Sussex Police
Serving Sussex

Local Policing Branch

Re: Land West of Brook Lane & South of A259 Angmering, BN16 3JL.

Thank you for your correspondence of 13th March 2017, advising me of an outline planning application (with all matters reserved) for demolition of existing buildings on site and the erection of a mixed use development comprising 90No residential units and a care home (Use Class C2 and C3) & ancillary facilities, including railway crossing, together with associated access, car parking & landscaping at the above location, for which you seek advice from a crime prevention viewpoint. My comments will be broad with more in-depth advice being delivered at reserved matters.

MASTER PLAN

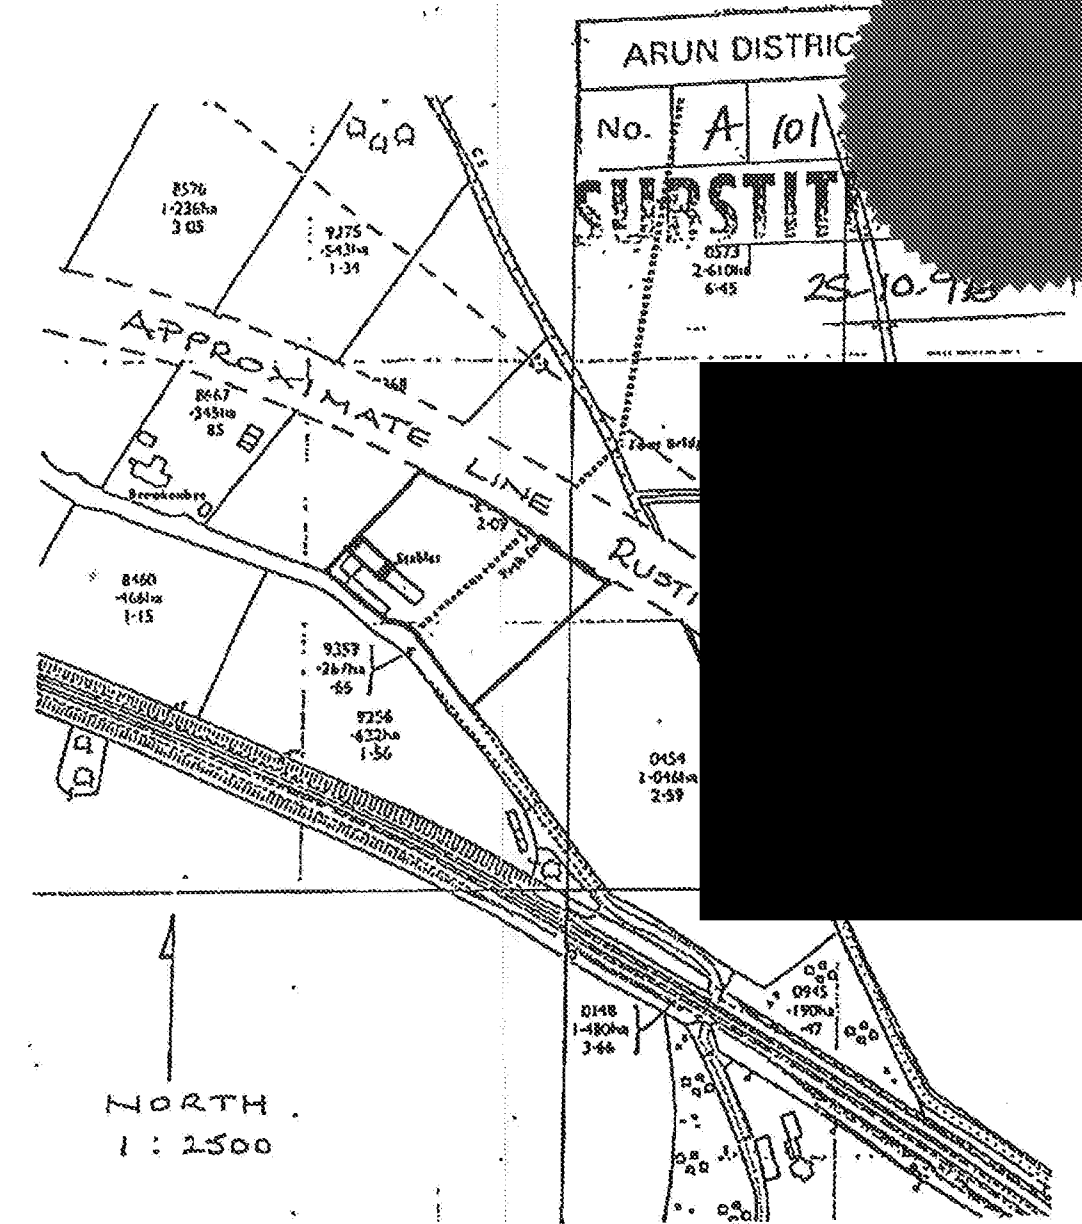
The development in the main has outward facing dwellings with back to back gardens which has created good active frontage with the streets and the public areas being overlooked. Parking in the main has been provided with in-curtilage, garage and a number of on street parking bays, this should leave the street layout free and unobstructed.

Where communal parking occurs it is important that they must be within view of an active room within the property. An active room is where there is direct and visual connection between the room and the street or the car parking area. Such visual connections can be expected from rooms such as kitchens and living rooms, but not from bedrooms and bathrooms. Gable ended windows can assist in providing observation over an otherwise unobserved area.

As the first line of defence, perimeter fencing must be adequate with vulnerable areas such as side and rear gardens needing more robust defensive barriers by using walls or fencing to a minimum height of 1.8metres. In circumstances that require a more open feature such as a garden overlooking a rear parking court or a rear garden pathway, 1.5metre high close board fencing topped with 300mm of trellis can achieve both security and surveillance requirements. This solution provides surveillance into an otherwise unobserved area and a security height of 1.8 metres.

Gates that provide access to the side of the dwelling or rear access to the gardens must be robustly constructed of timber, be the same height as the adjoining fence and be lockable from both sides. Such gates must be located on or as near to the front of the building line as possible.

Areas of play should be situated in an environment that is stimulating and safe for all children, be overlooked with good natural surveillance to ensure the safety of users and the protection of equipment, which can be vulnerable to misuse. I would recommend that the eventual location is surrounded with railings with self-closing gates to provide a dog free environment.
